Gatwick Airport Northern Runway Project

Response to the Examining Authority's Written Questions (ExQ1) – Water Environment

Application Document Ref: 10.16

PINS Reference Number: TR020005

DAYLIGHTED CHANNEL EXTENSION OF RIVER MOLE

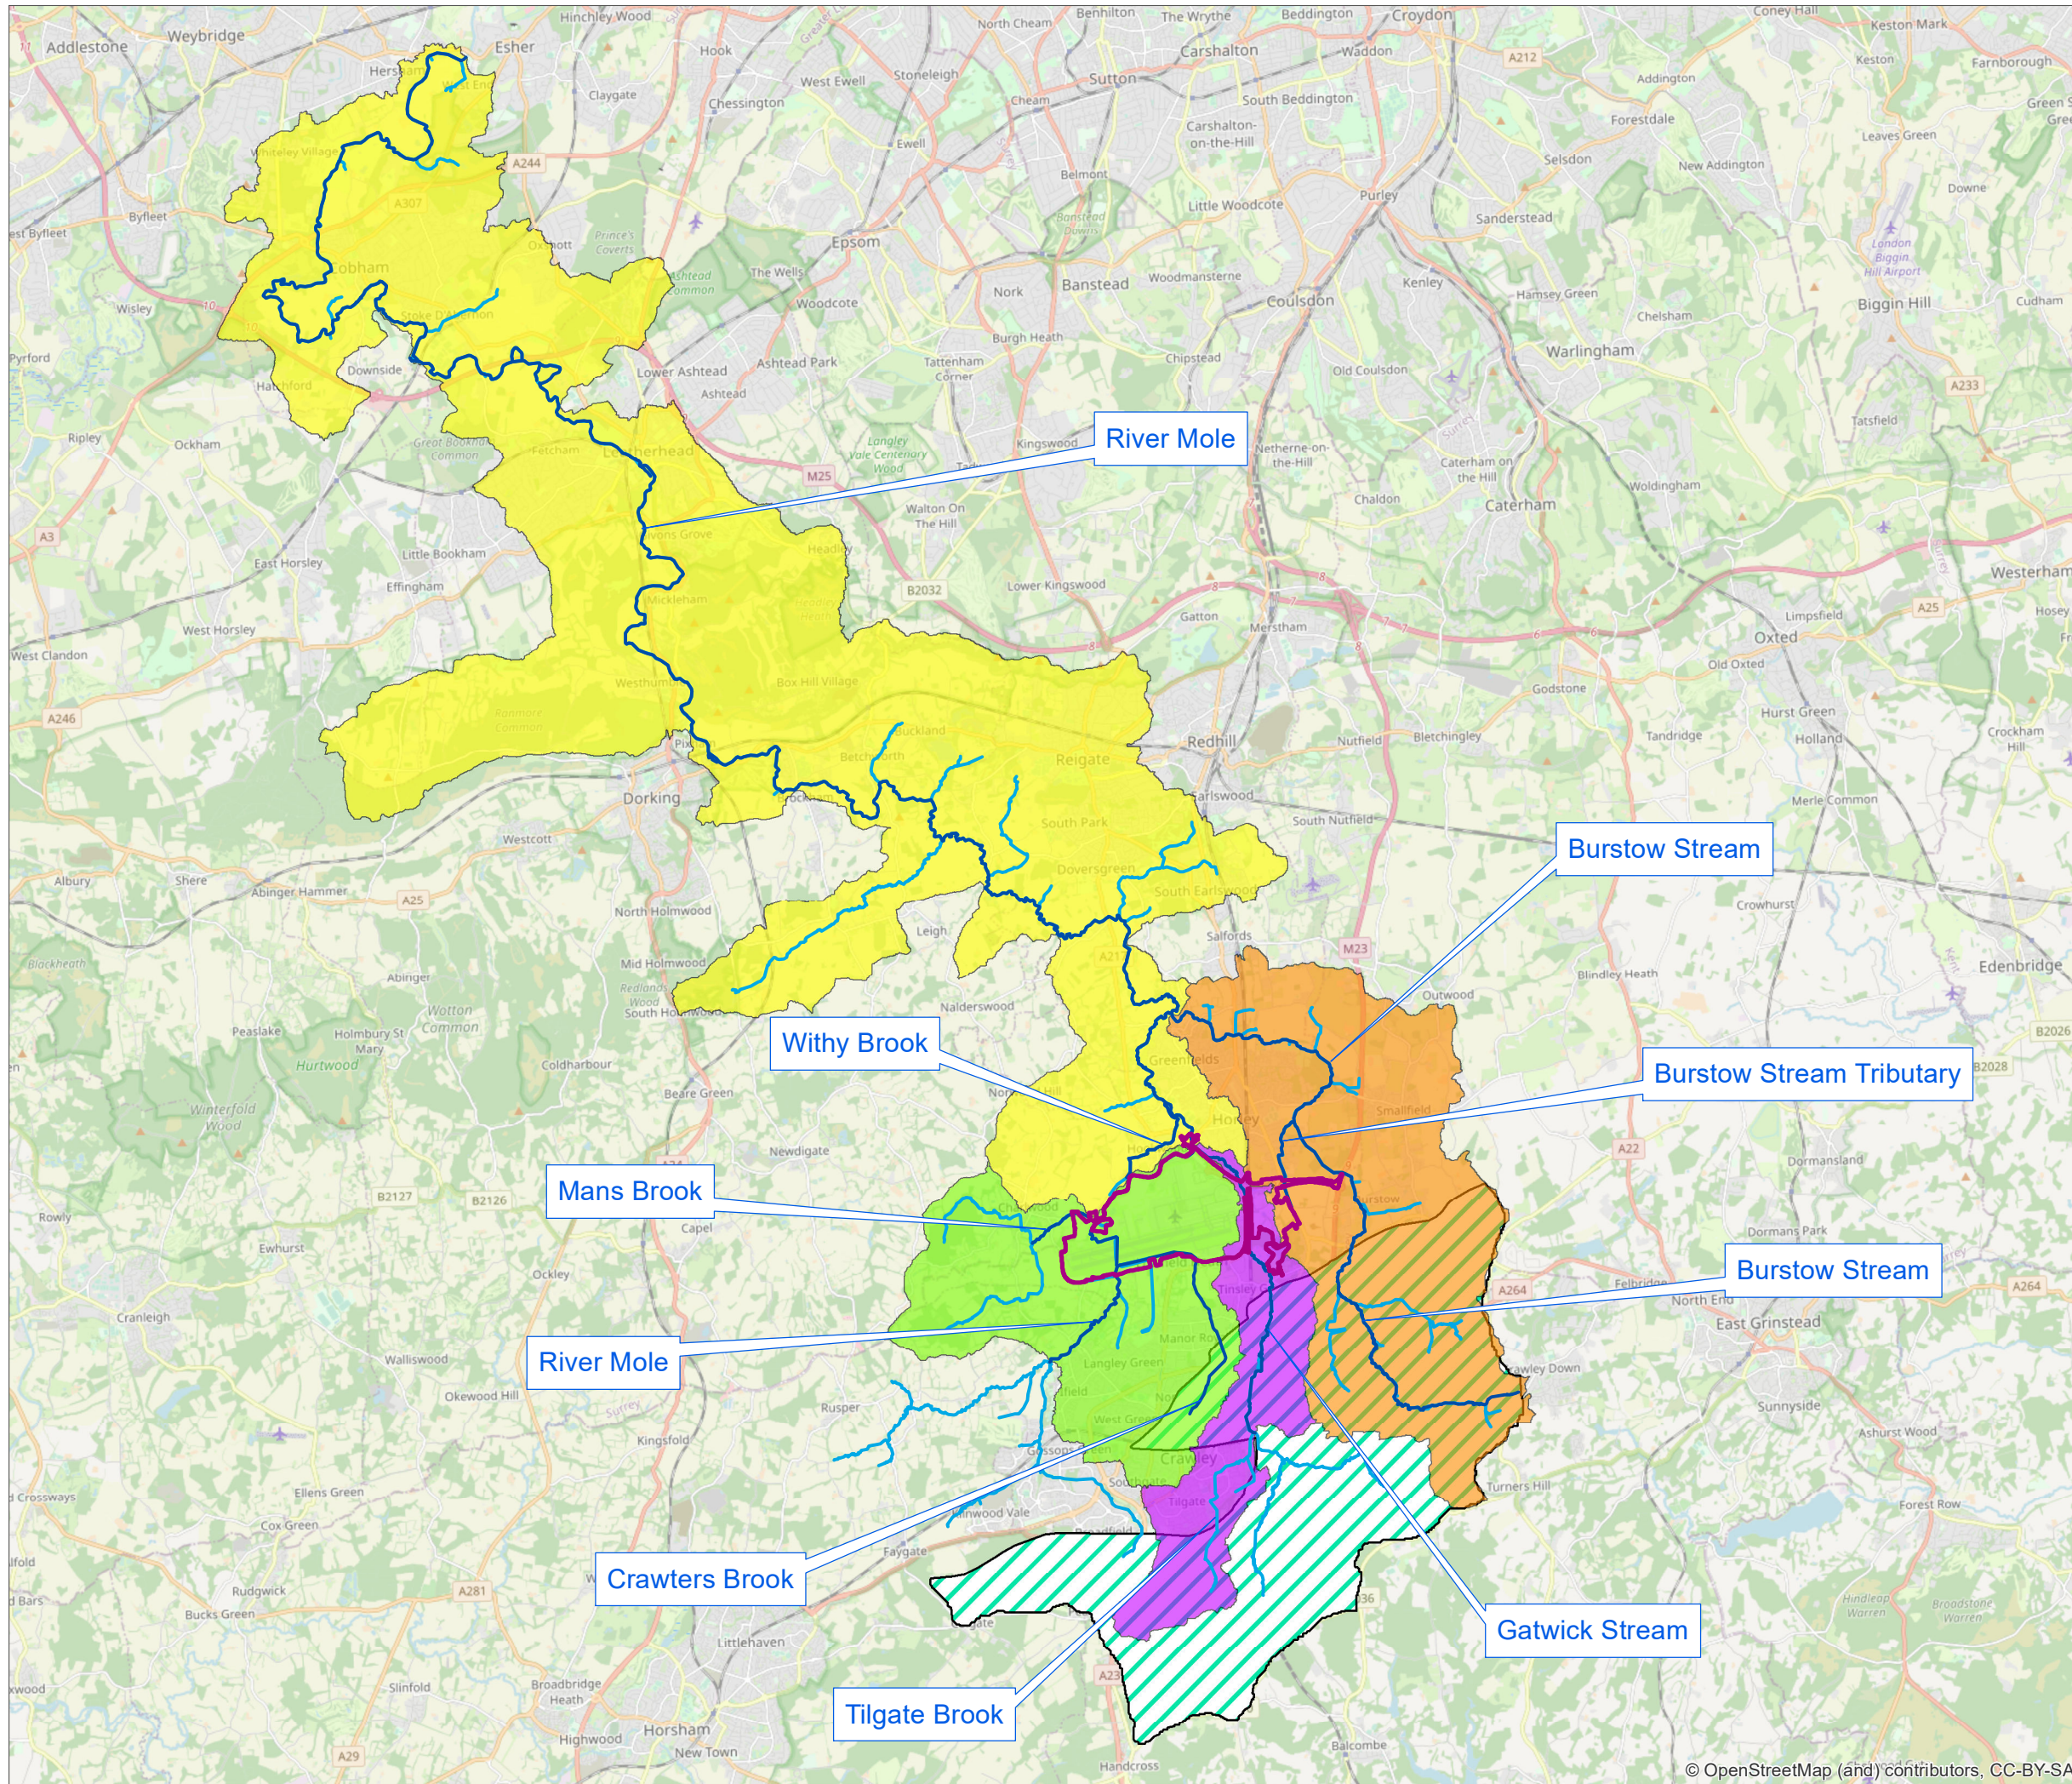
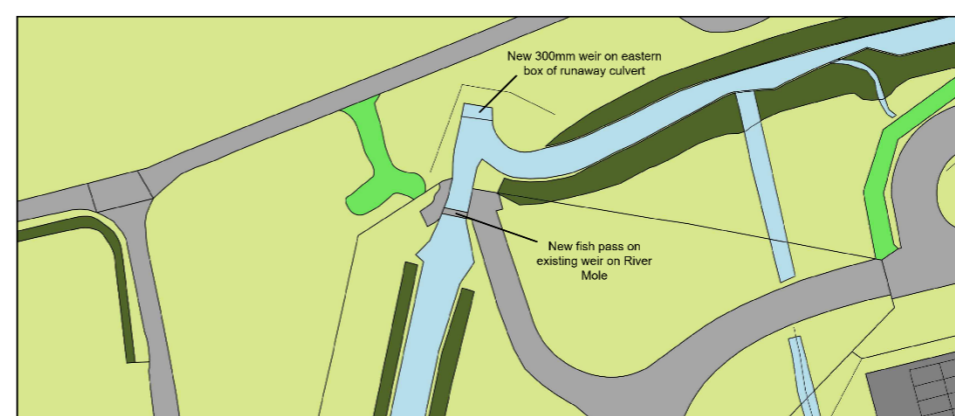
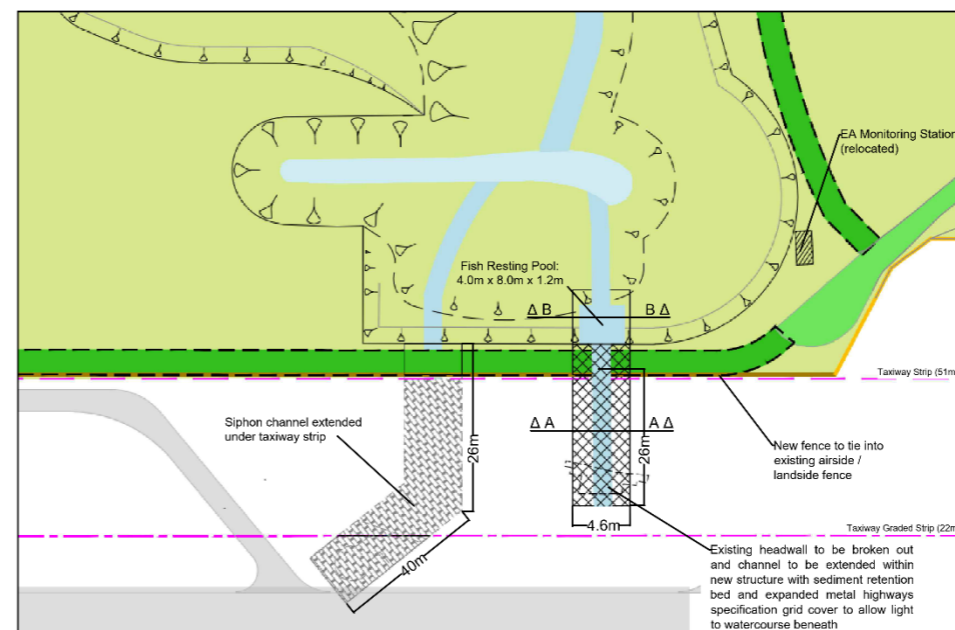
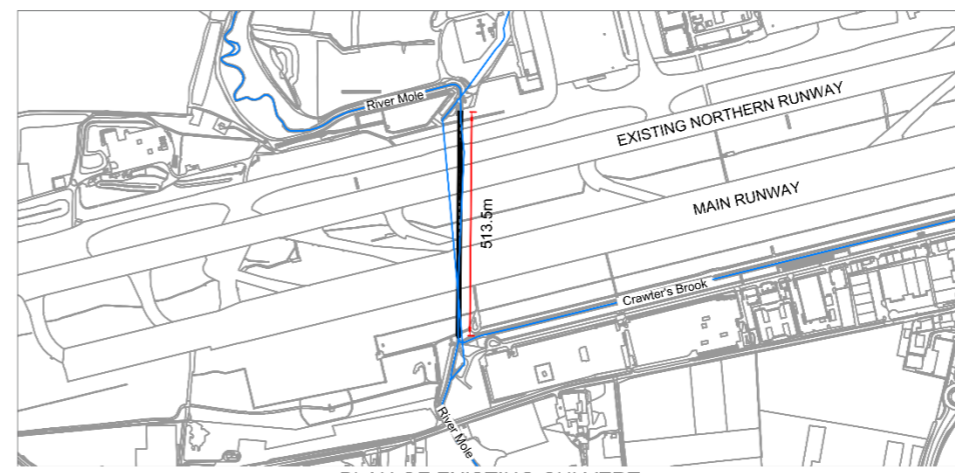
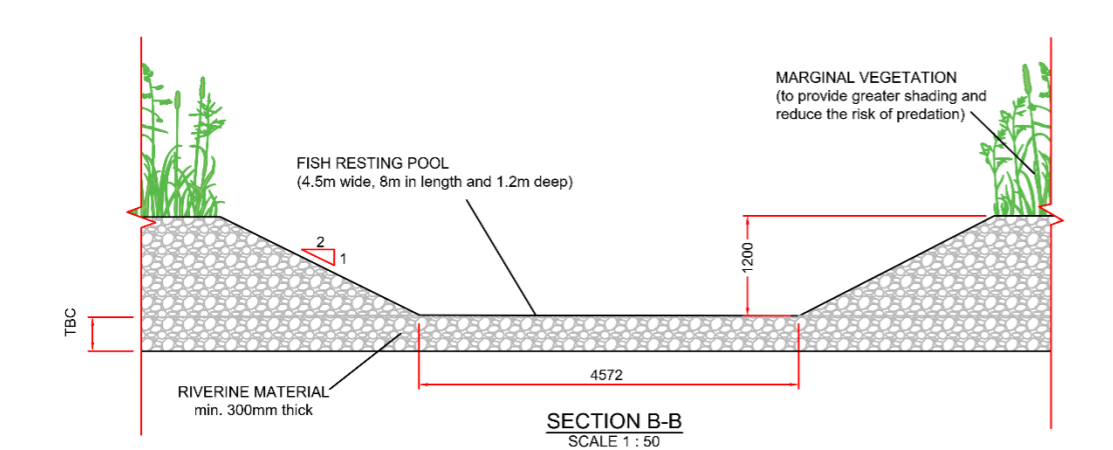
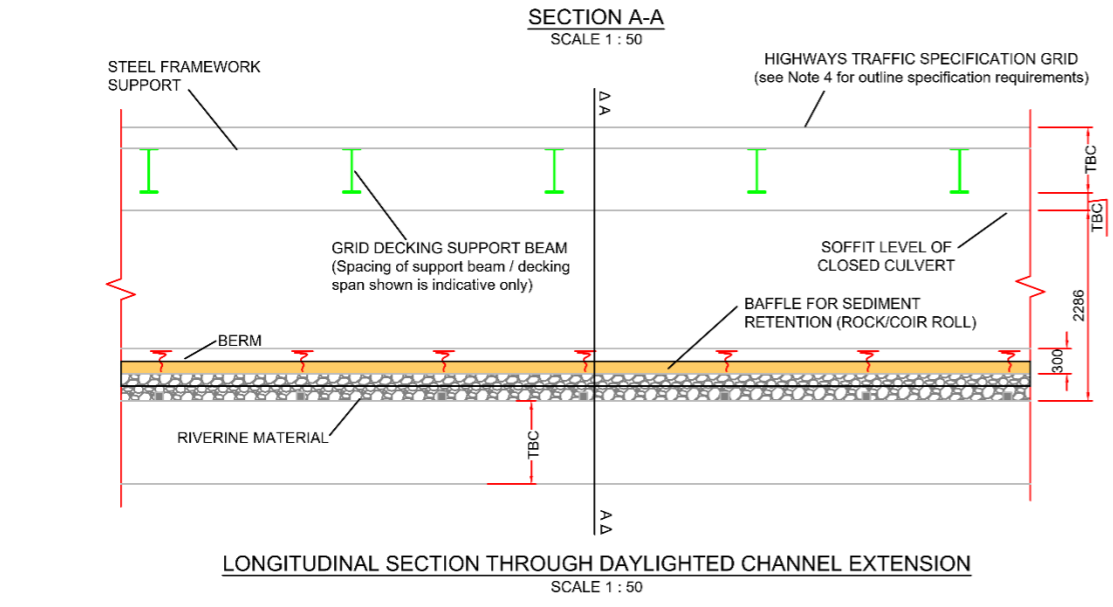
WE.1.11	The Applicant	<p>ES Chapter 11 – Water Environment</p> <p>Table 11.8.1 of ES Chapter 11 [APP-036] sets out mitigation, monitoring and enhancement measures. This includes ‘new section of River Mole channel at existing runway culvert exit’. Provide a diagram showing the alterations to the River Mole culvert at this point.</p> <p>An indicative design drawing of the extended section of the River Mole culvert is included in ES Appendix 11.9.2 Water Framework Directive Compliance Assessment Annex 1 [APP-143]</p>
WE.1.12	The Applicant	<p>ES Chapter 11 – Water Environment</p> <p>The penultimate sentence of Paragraph 11.9.42 of ES Chapter 11 [APP-036] contains a clear</p>

- Legend**
- Project Site Boundary
  - Environmental Feature
  - Gatwick Biodiversity Area
  - Sewage Treatment Work
  - Watercourse
  - Artificial Waterbody

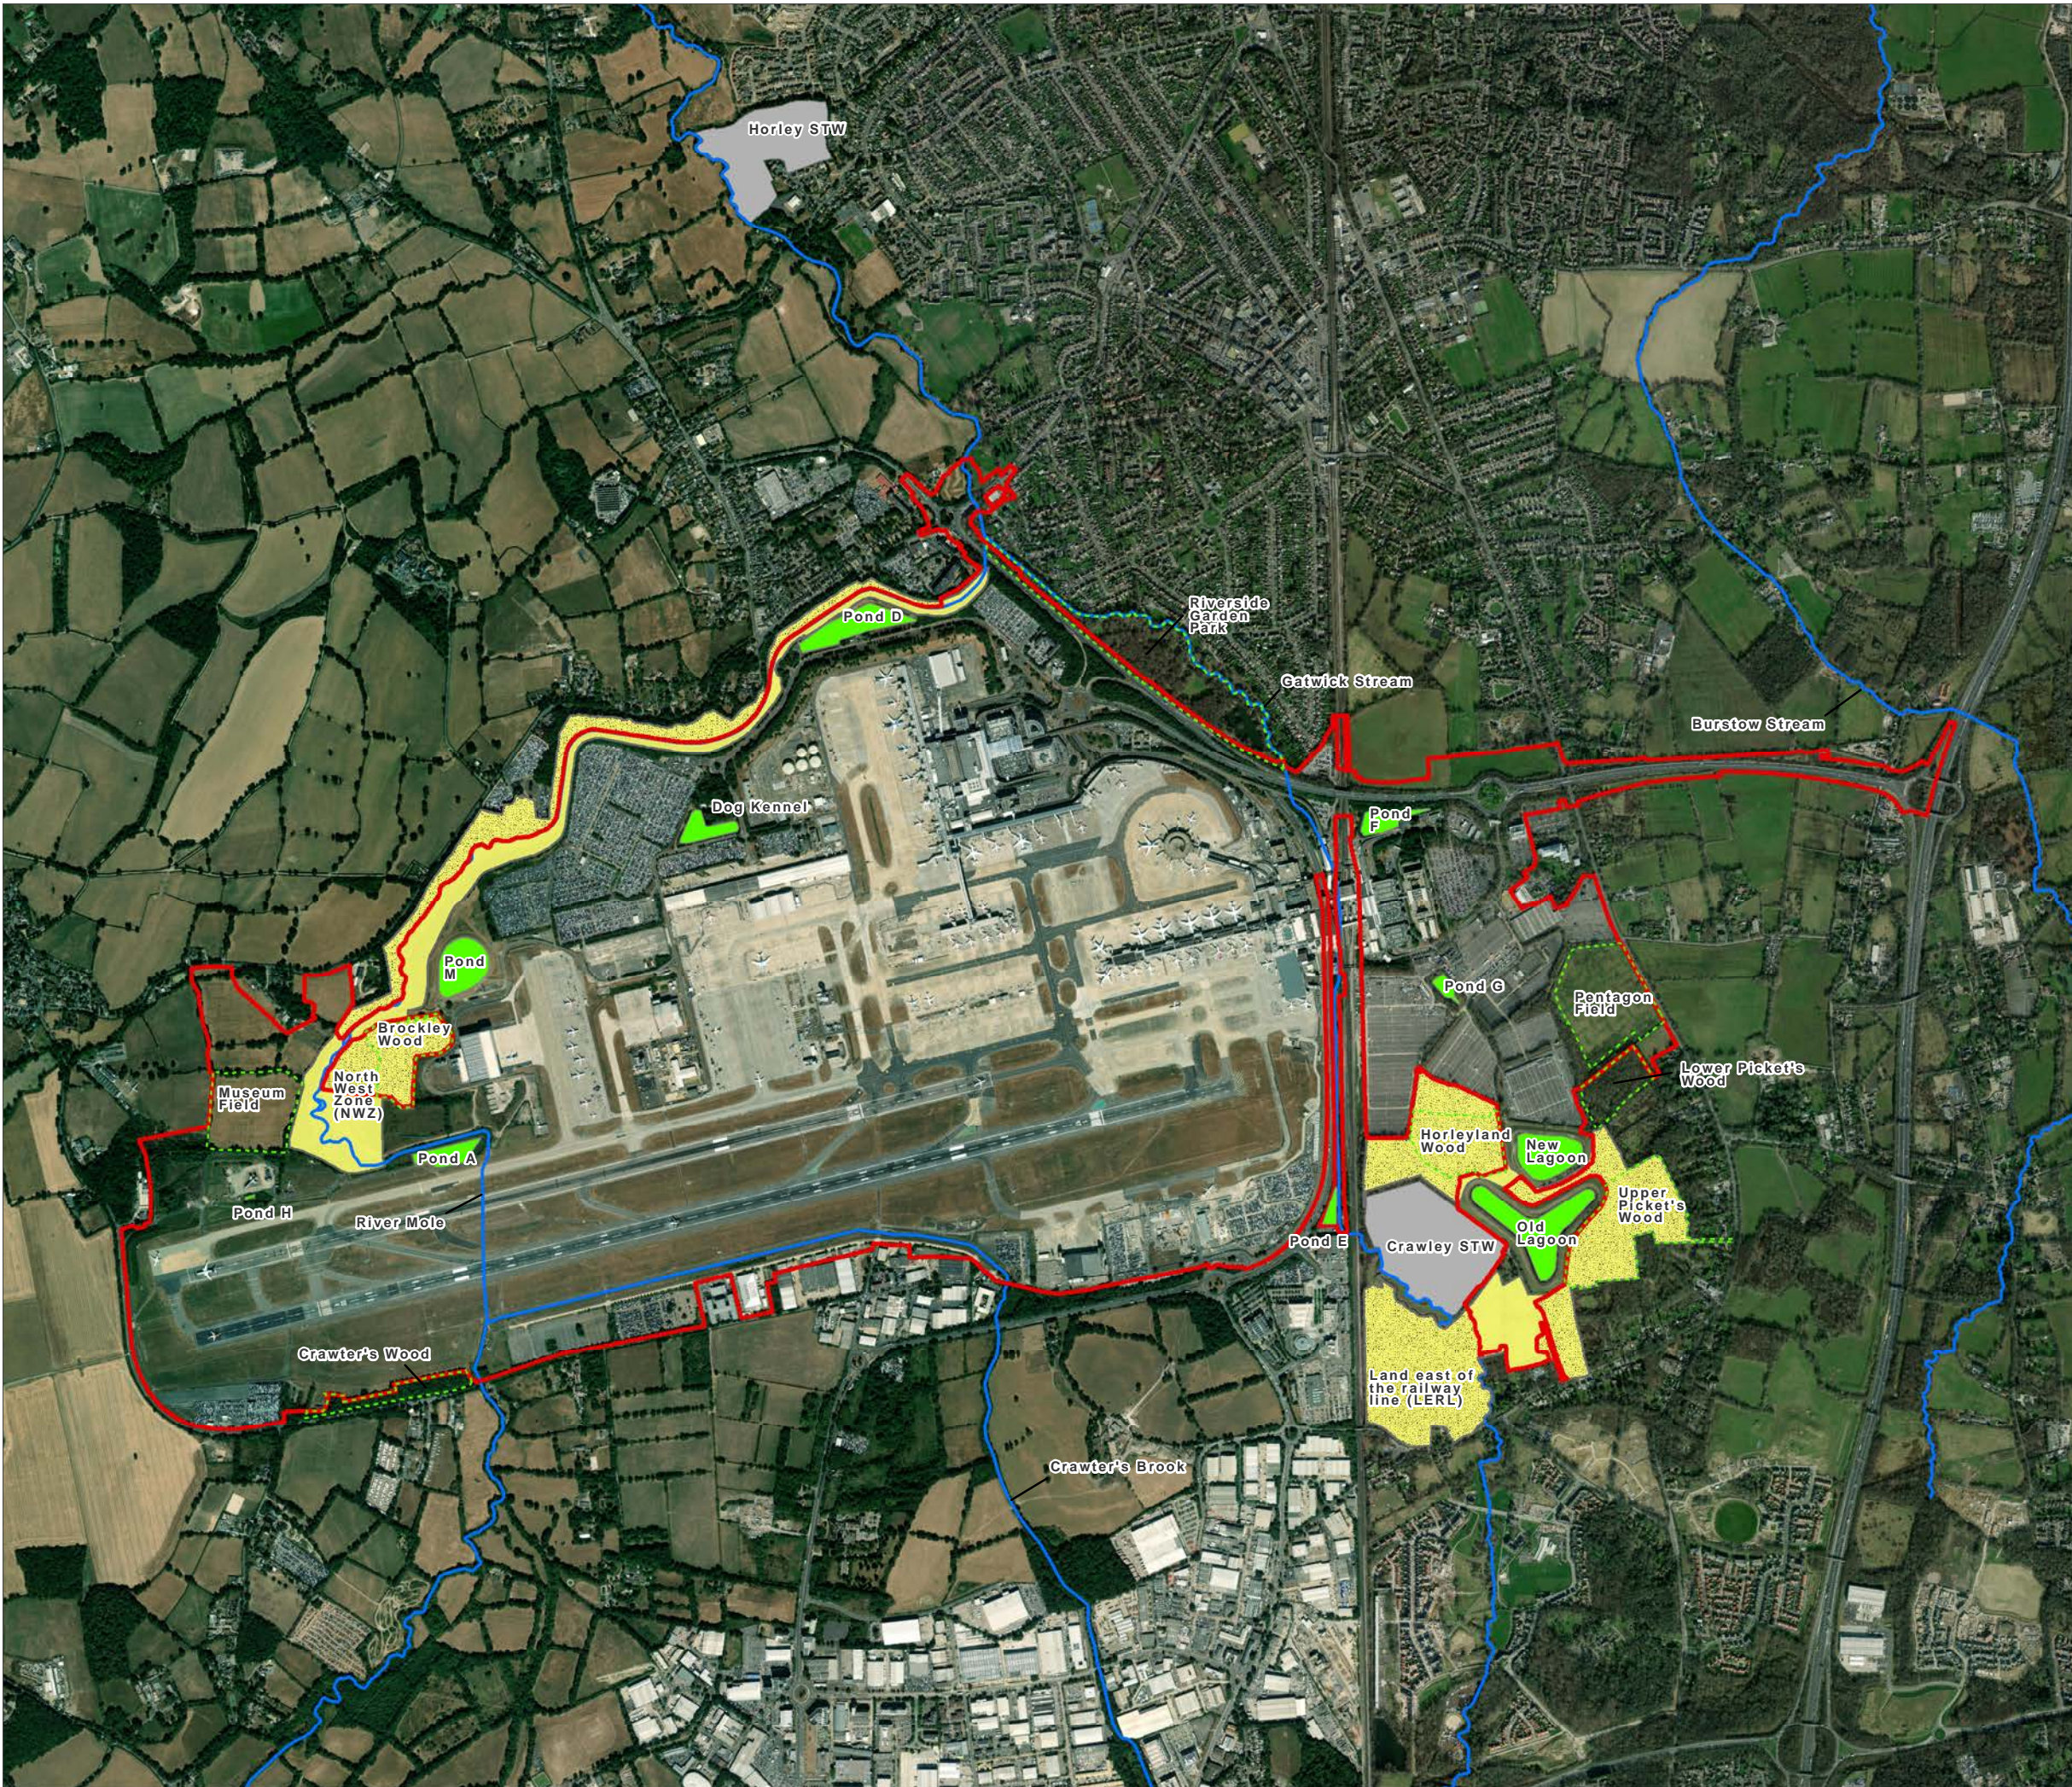
ExQ1	Question to:	Question:
WE.1.1	The Applicant	<p>ES Chapter 4 Existing Site and Operation</p> <p>Paragraph 4.2.31 of ES Chapter 4 [APP-029] references Ponds A, D to H, Pond M and Dog Kennel Pond. No reference is made to Ponds B or C in the text or on Figures 4.2.1c or 11.6.1.</p> <p>Clarify the location of Ponds B and C.</p> <p>Ponds B and C were located to the east of Pond A but have not existed for some time and so are not existing environmental features and therefore are not referenced in the referenced figure or in ES Chapter 4: Existing Site and Operations.</p>
WE.1.2	The Applicant	<p>Impermeable Areas.</p> <p>Within the OL [APP-013] what is the current total impermeable area associated with:</p> <ul style="list-style-type: none"> • The current site layout; • The future baseline site layout; and • The Proposed Development site layout. <p>Airfield</p> <p>The current total airfield impermeable is 3.94km², this would increase to 4.07km² with the Project. There is a very minor increase in the future baseline of 0.523ha against the current position.</p> <p>Surface Access</p>
